Cc: Rosemarie Dannatt
Subject: Application AL/23/17/DOC Aldingbourne Farm Shop site, Nyton Road

I write further to the submission of details of the lighting (condition 10).

Appendix 5

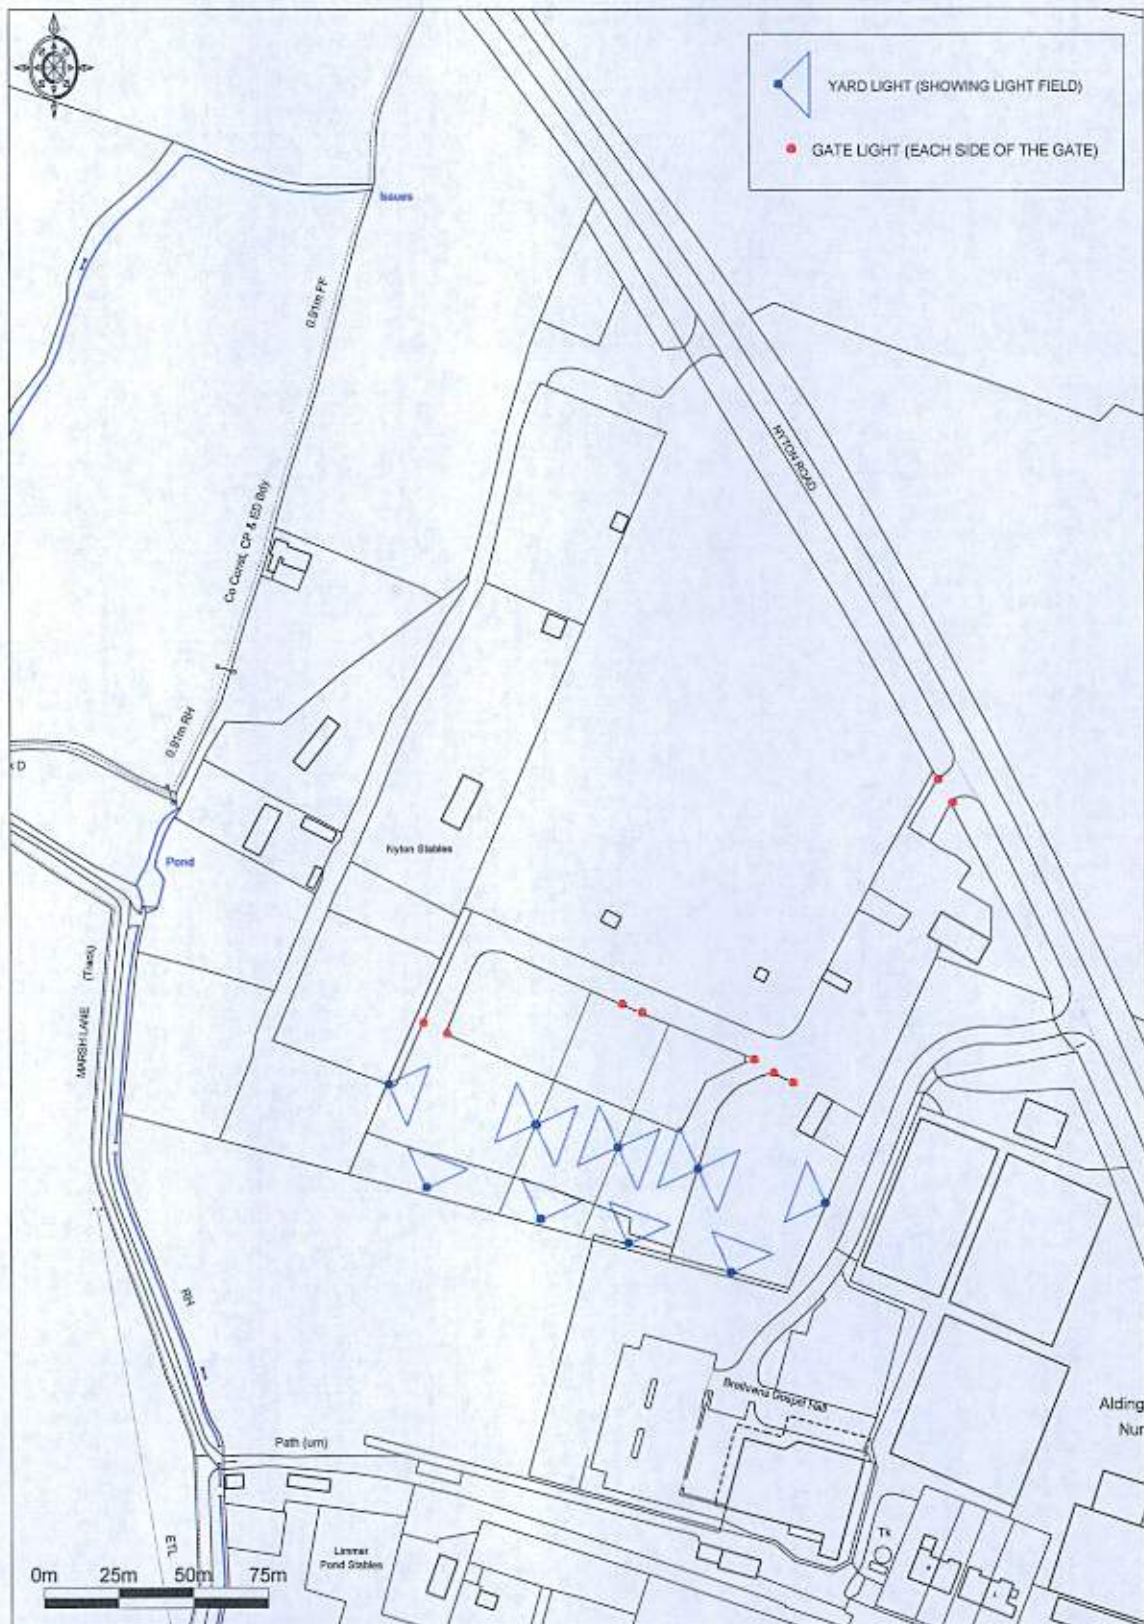
We are therefore reluctant about approving floodlighting (column mounted lights) on the site. Can you give me some justification as to why these are necessary and why low level lighting is not sufficient. Can you also advise why there is a need for some many column mounted lights are per the plan submitted previously (Appendix 5 of the original AL/23/17/DOC submission).
